Conservation Area Advisory Committee

Meeting Date : 14 Mar 2012

BUILDING REGULATION NOTES

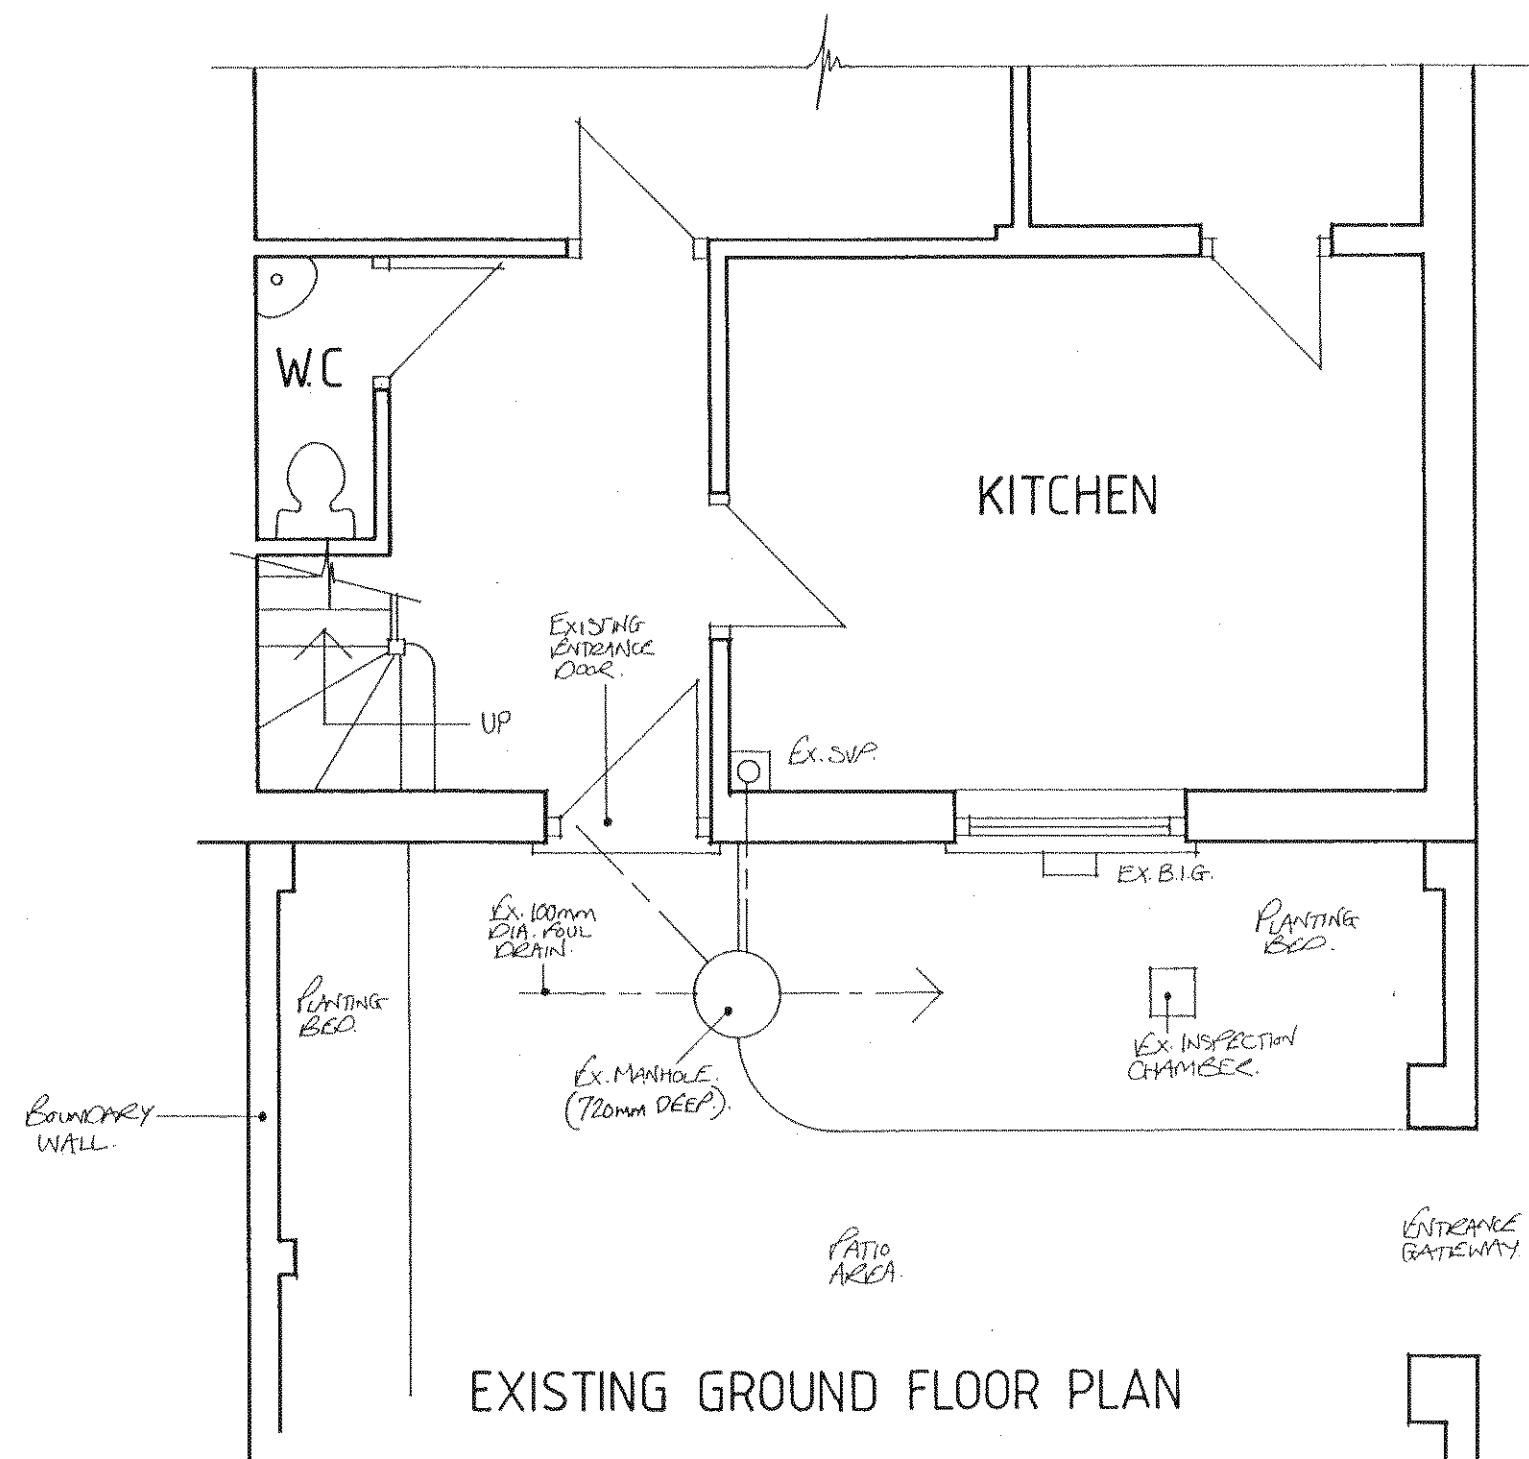
App No	Description/Address	Comment	Recommendation/Observation
<u>R/72/12/</u> 1	Proposed front porch. Manor Cottage 2 West Preston Manor Station Road Rustington BN16 2AF	No objection	High quality materials and details should be used
<u>R/73/12/L</u>	Application for Listed Building Consent for proposed front porch Manor Cottage 2 West Preston Manor Rustington BN16 2AF	No objection	
<u>R/92/12/TC</u>	Reduce 2no. Sycamore trees by 50% within the Rustington Conservation Area Elm Farm 34 The Street Rustington BN16 3PA	No objection
